Re:- 89 BROADMARK LANE, RUSTINGTON, BN16 2JA

We have been sent a copy of proposals by Mr and Mrs Gale's Architect Paul Trussler to extend and alter this adjacent house. Our two main concerns are soundproofing and guaranteed weather proofing to the party wall. There is also no detail as to the elevation materials to the raised garage roof (as seen from the road).

Proposed Ground Floor Plan
Scale: 1/100

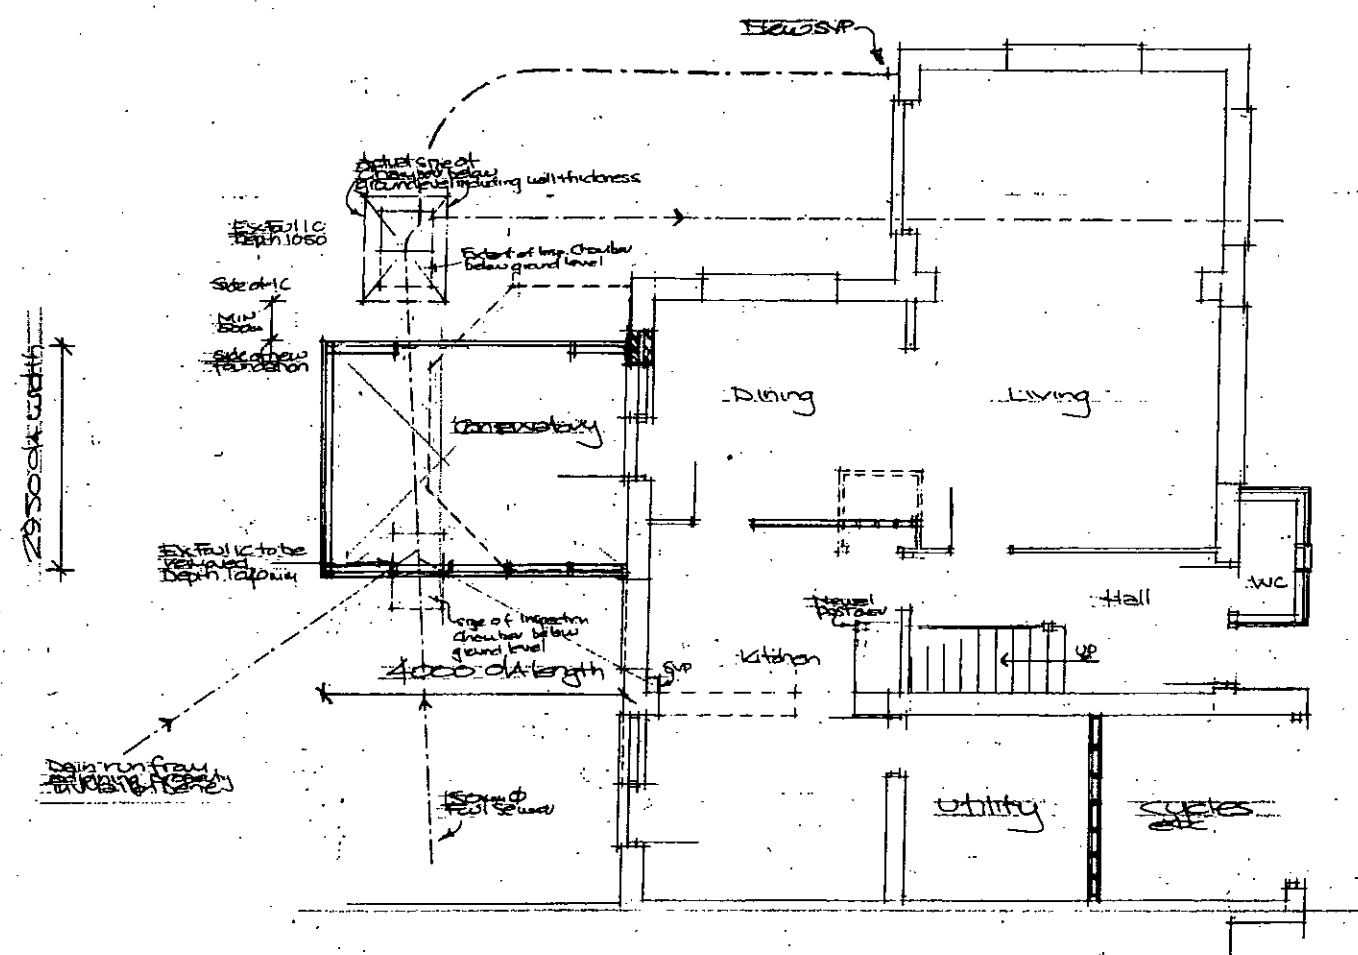
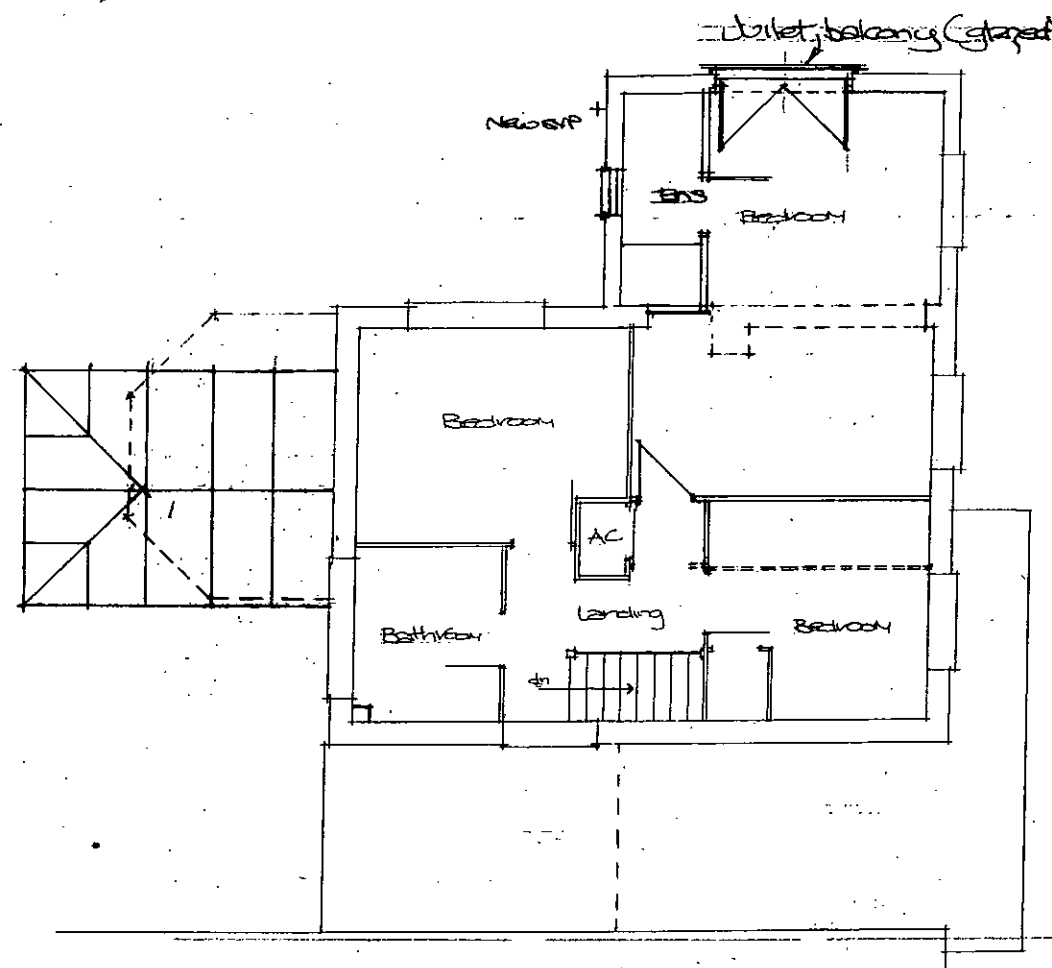
Regarding soundproofing we are particularly worried about noise from washing machines, dishwasher etc., affecting our enjoyment of our living room and also because of the raised height – possibly the two bedrooms.

Proposed Roof Plan
Scale: 1/200

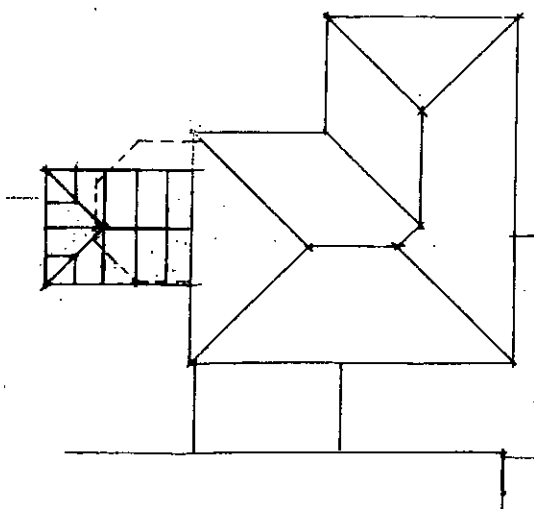
Weather tightness to the party wall is obviously very important – we do not want rainwater penetration causing dampness to our house. Bearing in mind the closeness to the sea and the prevailing wind and rain, suitable flashings and trays are vital, as is surface water drainage from the flat roofs.
